Appeal Decision

Appeal Ref: APP/R5510/D/23/3333223

21 Cherry Orchard, West Drayton, UB7 7JR

- The appeal is made under section 78 of the Town and Country Planning Act 1990 against a refusal to grant planning permission.
- The appeal is made by Mr & Mrs A Singh against the decision of the Council of the London Borough of Hillingdon.
- The application Ref 50692/APP/2023/2207, dated 23 July 2023, was refused by notice dated 29 September 2023.
- The development proposed is a single storey rear and two storey side extension.

Dwg. No. AS/01/23 Rev. C

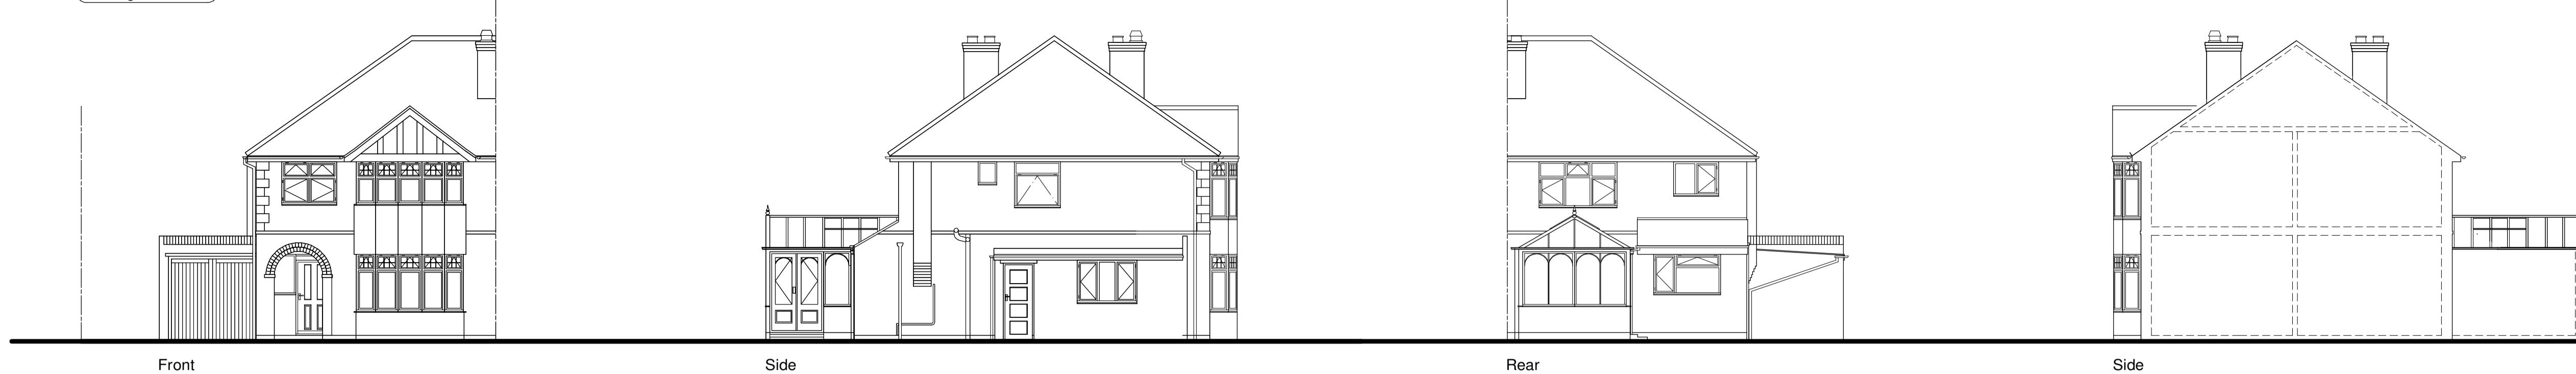
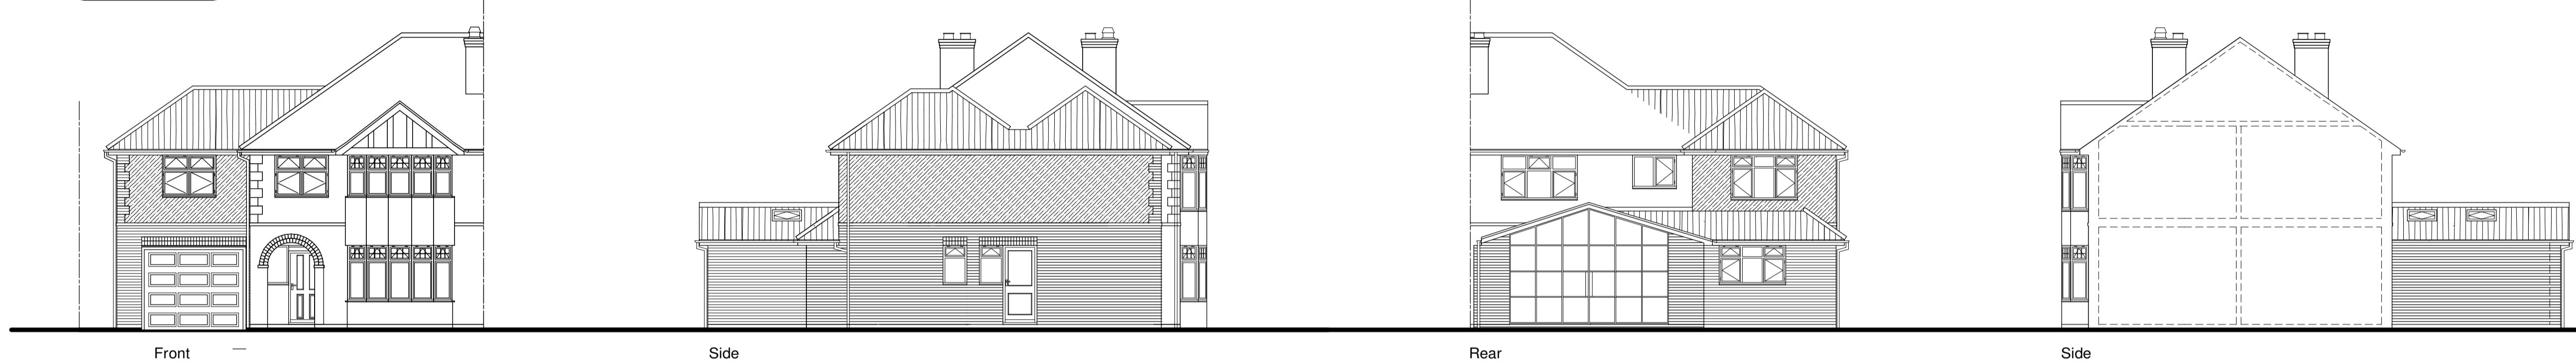
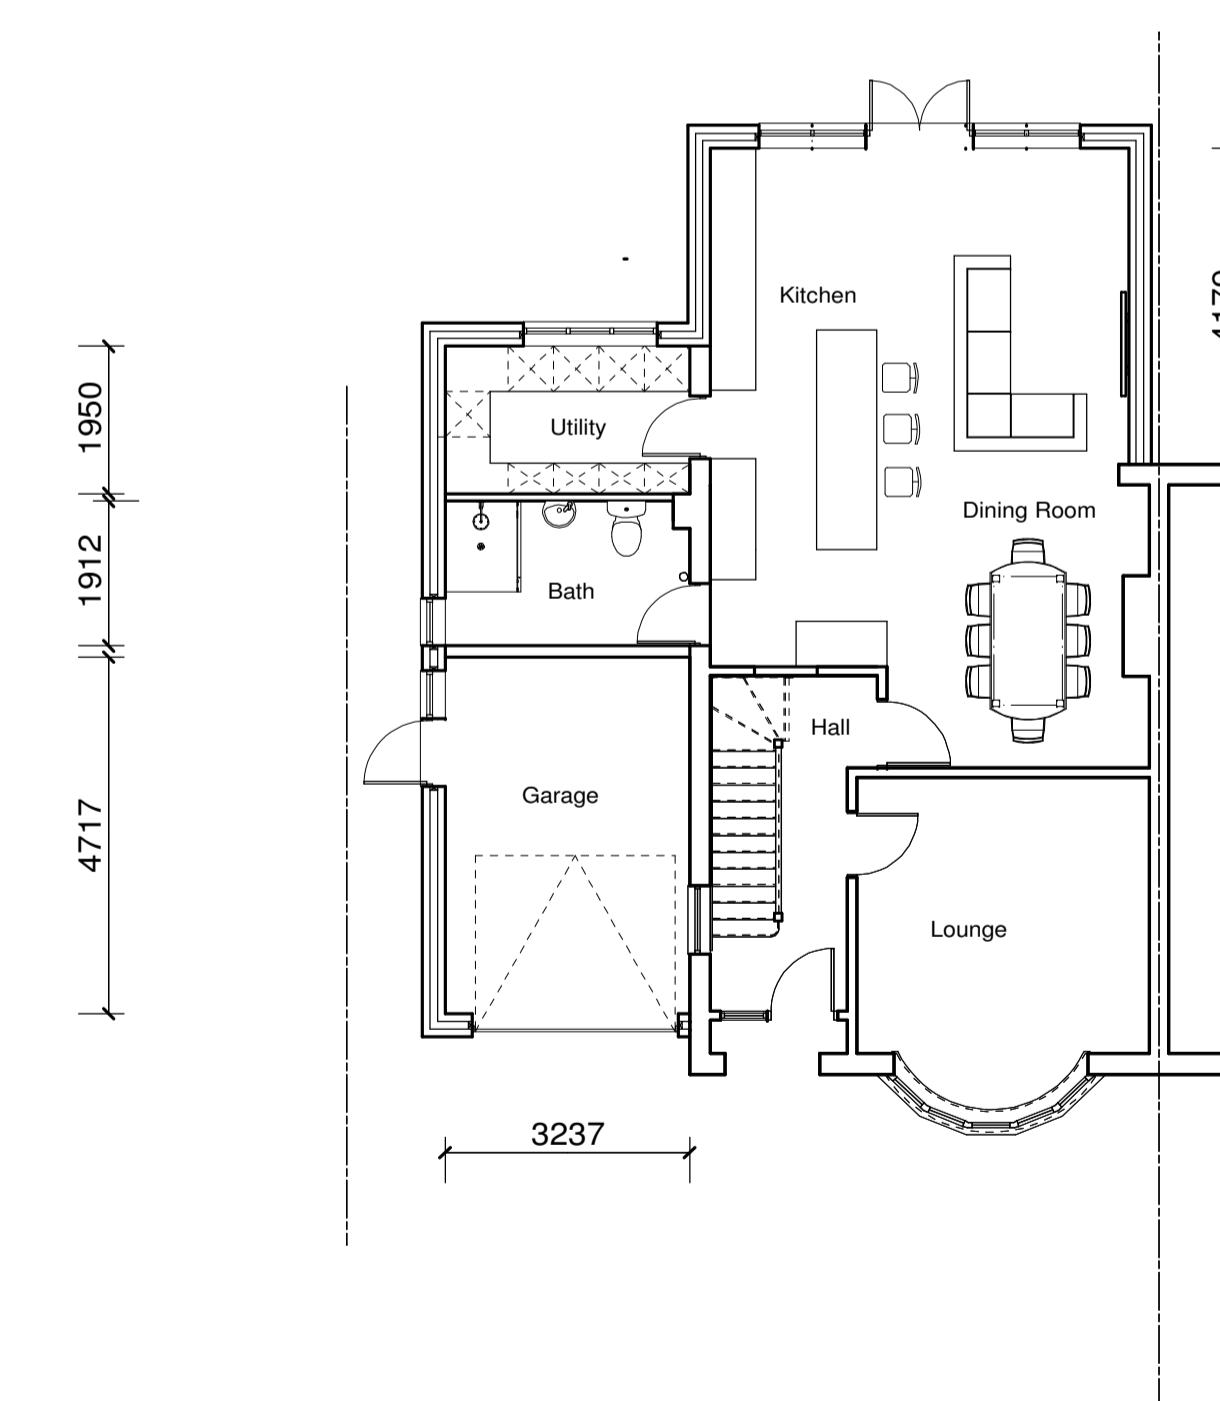
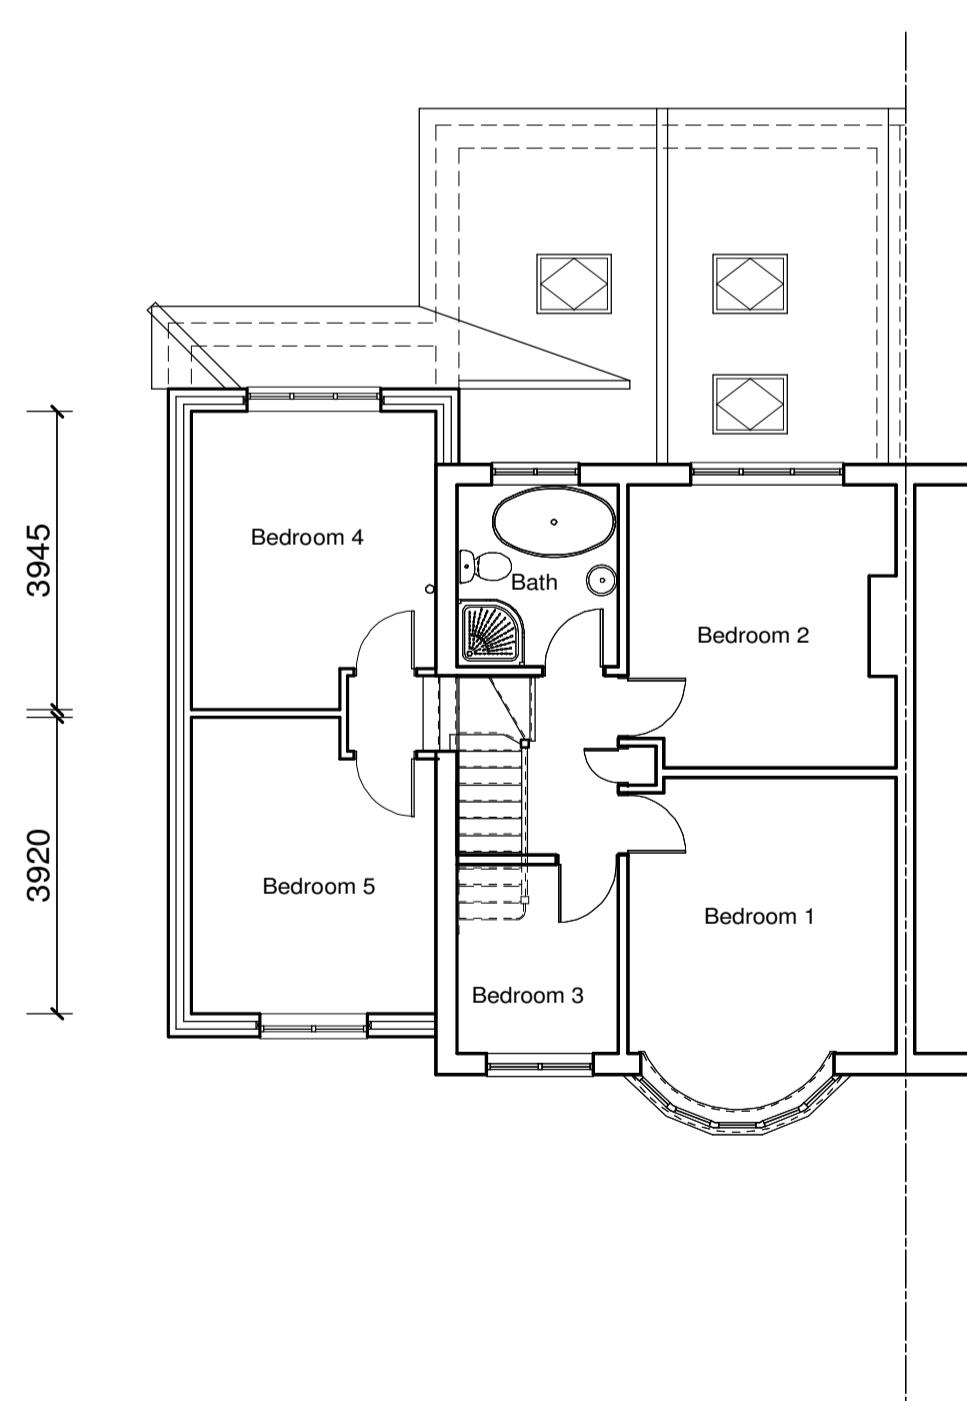
5. Judging from the officer report, it is the proposed side extension which caused concern in terms of its effects on local character and the host property's appearance. I note that the permitted scheme has been slightly reduced in scale. The first floor front wall of the permitted side extension would be recessed a little more than in the appeal scheme, and the extension would be reduced in width³ by 27mm, or by roughly an inch.

6. To my mind, the amendments made to gain the Council's acceptance would be barely discernible in the street scene in comparison with the appeal scheme, which I found to be well designed and of an appropriate scale, being clearly subservient to that of the host property.

8. The appellants intend demolishing the existing conservatory, which would be replaced by a rear extension. The Council granted permission recently for a rear extension of a similar appearance to that proposed now, but which is approximately 0.7m less deep than the one proposed in the appeal scheme.

9. One of the conservatory's side walls runs on the boundary shared with No 35, and this is of solid construction. The depth of the solid side wall in the recently approved scheme is comparable to that of the existing conservatory. The main judgment to be made therefore is whether the additional depth proposed in the appeal scheme would be such as to render it unacceptable in comparison with the approved scheme, taking into account existing site conditions.

10. In this respect I noted that a high hedge runs beyond the conservatory along the common boundary into the garden for a distance well beyond 0.7m. The additional depth proposed in the appeal scheme would have no greater impact on neighbouring living conditions than the hedge with particular reference to light and overshadowing. As to visual impact, in my judgment the additional 0.7m involved would have little material effect in comparison with the approved scheme.

1. The appeal is allowed and planning permission is granted for a single storey rear and two storey side extension at 21 Cherry Orchard, West Drayton, UB7 7JR in accordance with the terms of the application Ref 50692/APP/2023/2207, dated 23 July 2023, subject to the conditions set out in the attached Schedule.
